**Recommendation Report for Planning Permission**

**REF NO:** A/3/18/PL

**LOCATION:** Land at Arundel Road/A27  
Angmering  
BN164EU

**PROPOSAL:** Change of use of land to storage (B8 Storage or Distribution), erection of barn & hardstanding (resubmission following A/111/17/PL).

1711056-SK01

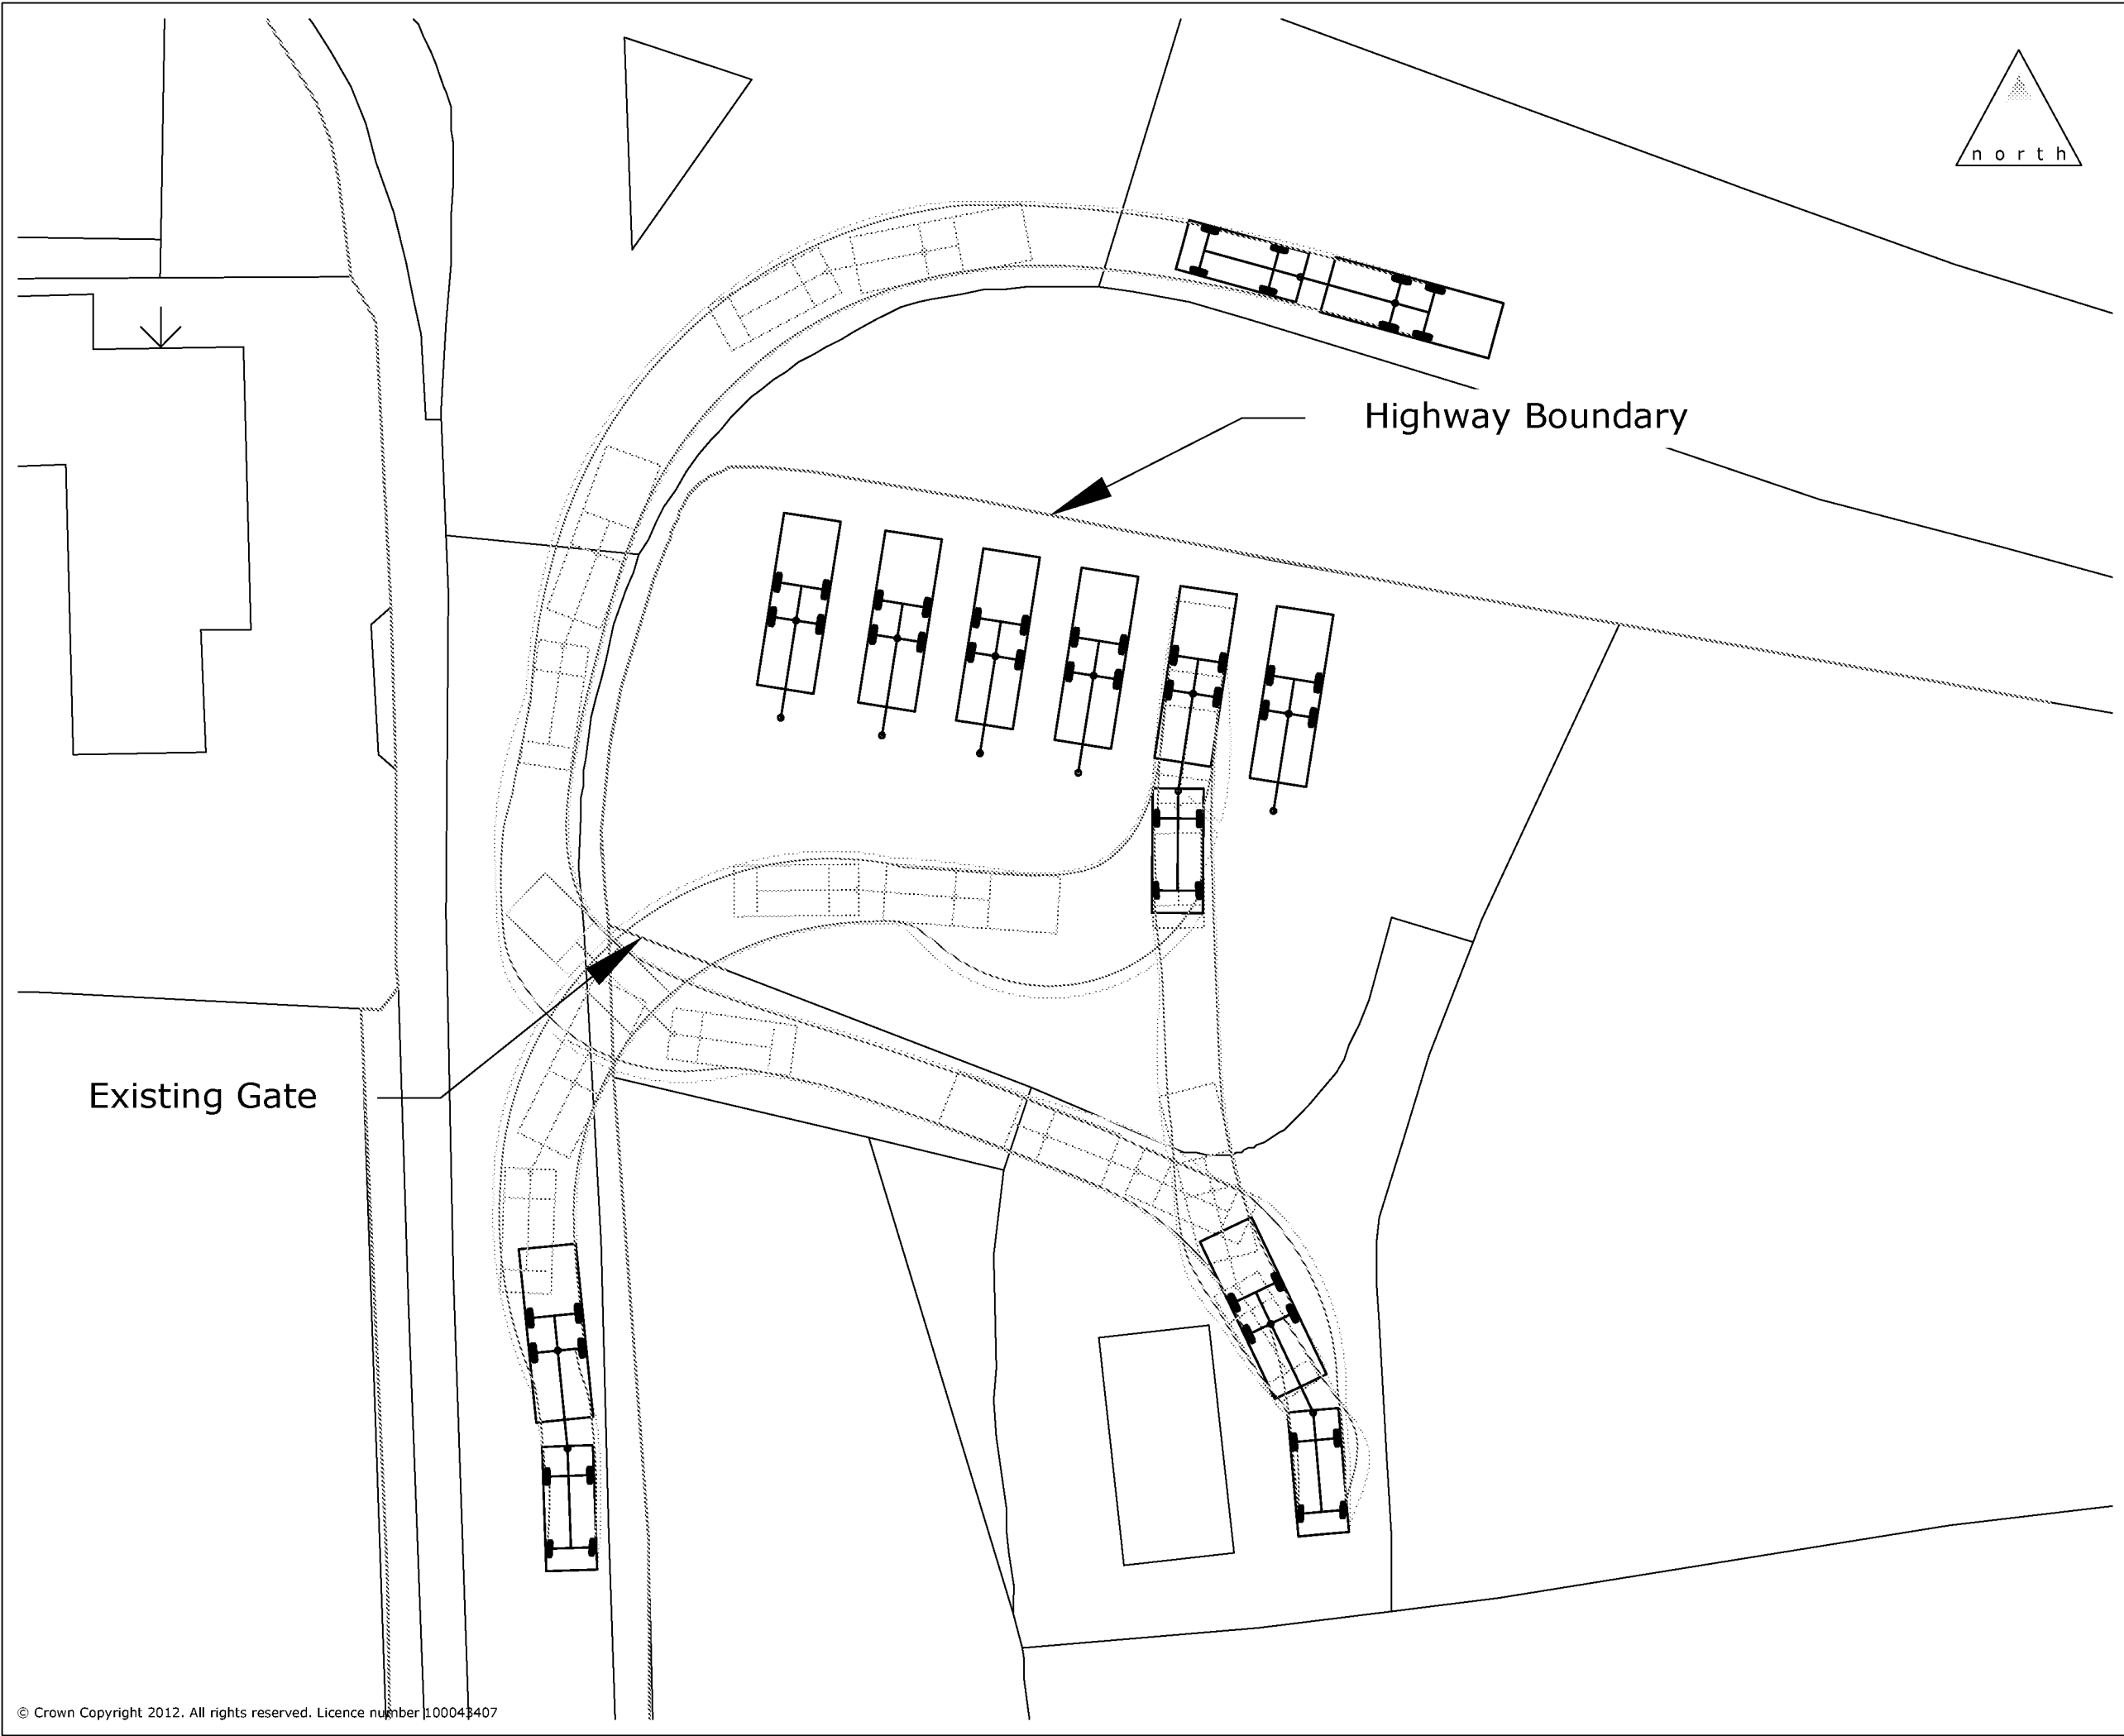
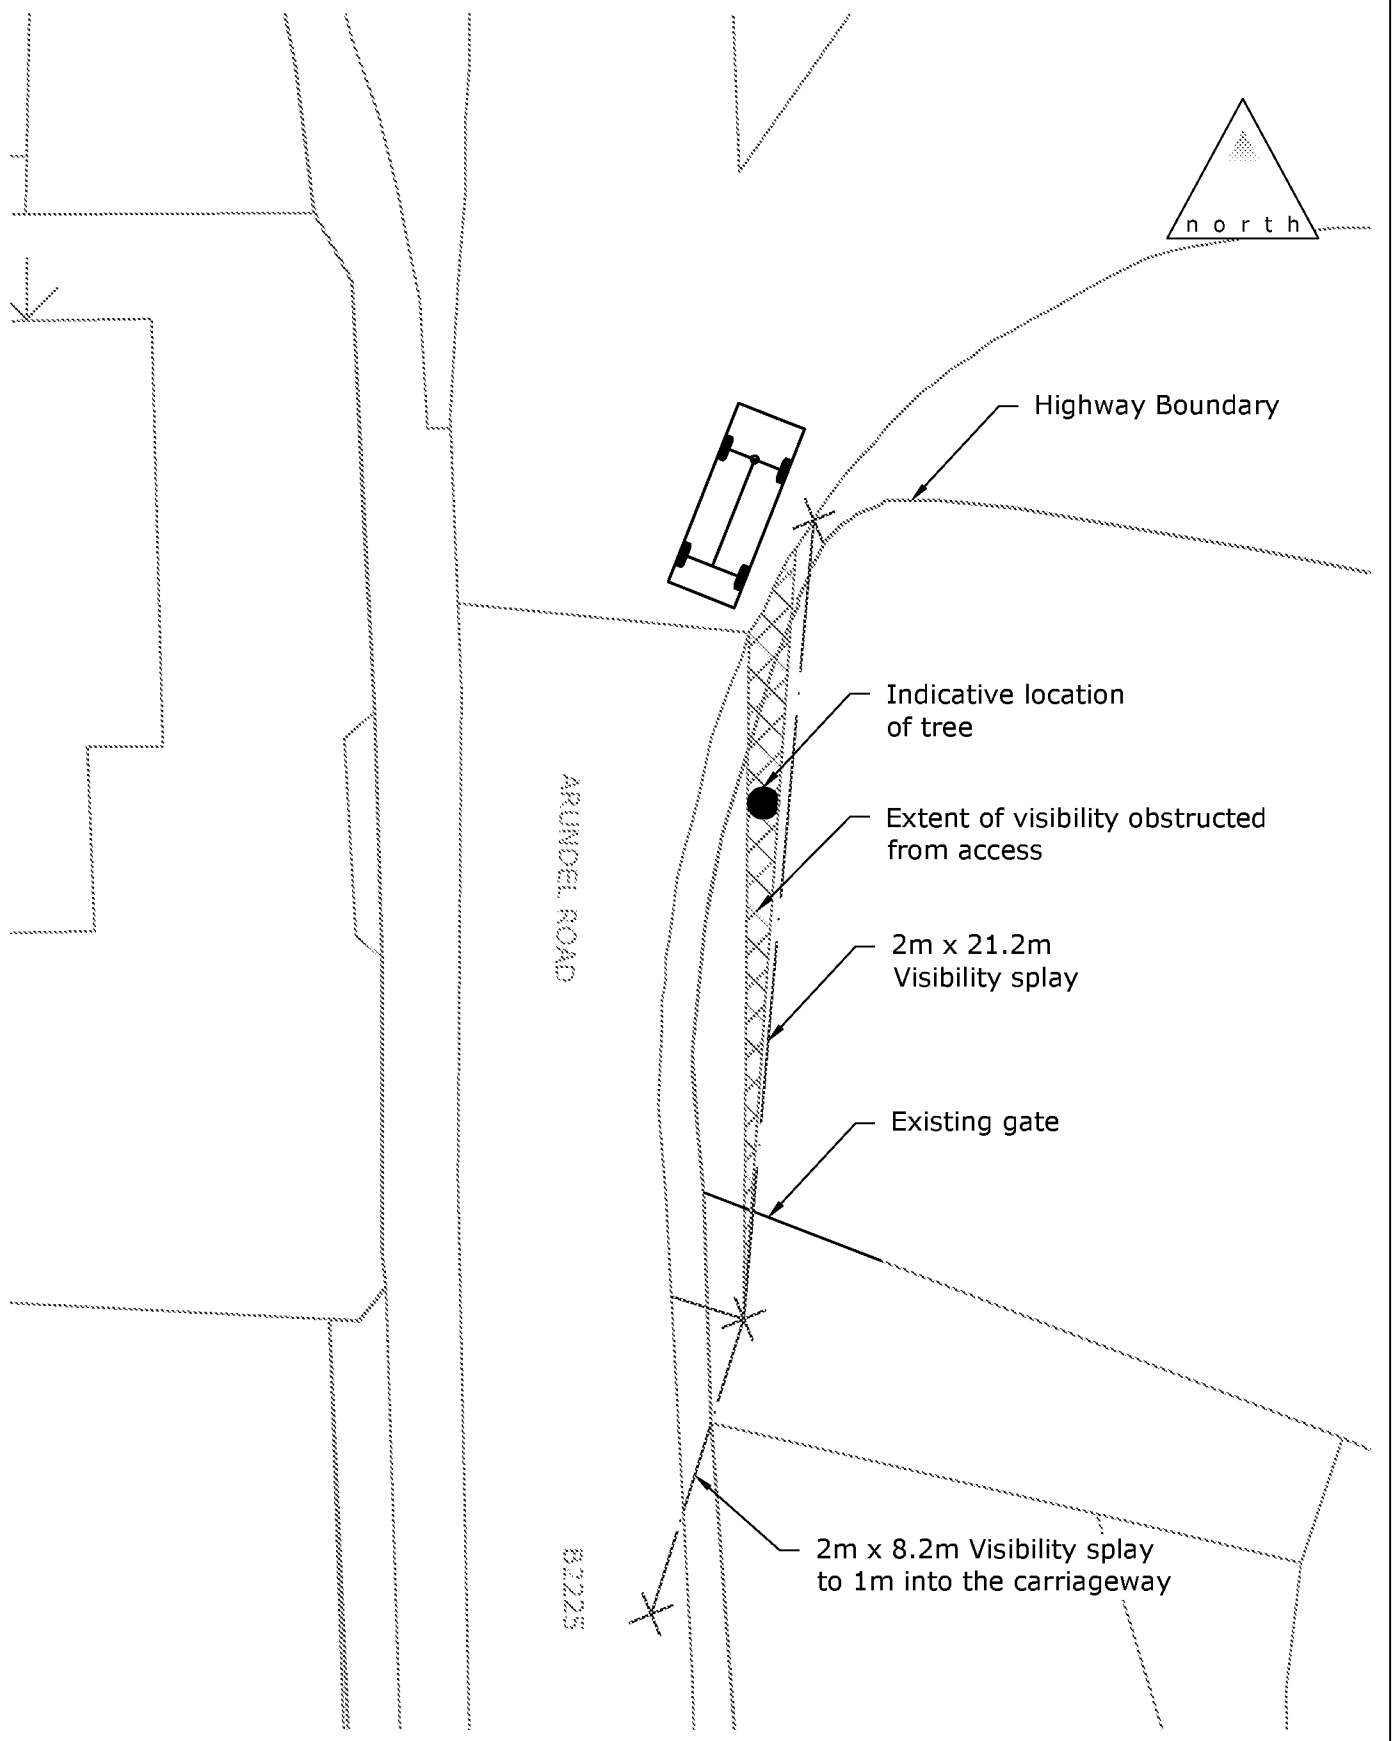
With regard to the tree, I would be minded to accept that the plan provided (1711056-SK01 Rev A) does demonstrate that that tree will not fully obstruct a vehicle within the envelope of visibility for a 21.1 metre visibility splay. I would ask this is accurately reflected in CAD if we get to the position where this is formally submitted for consideration.
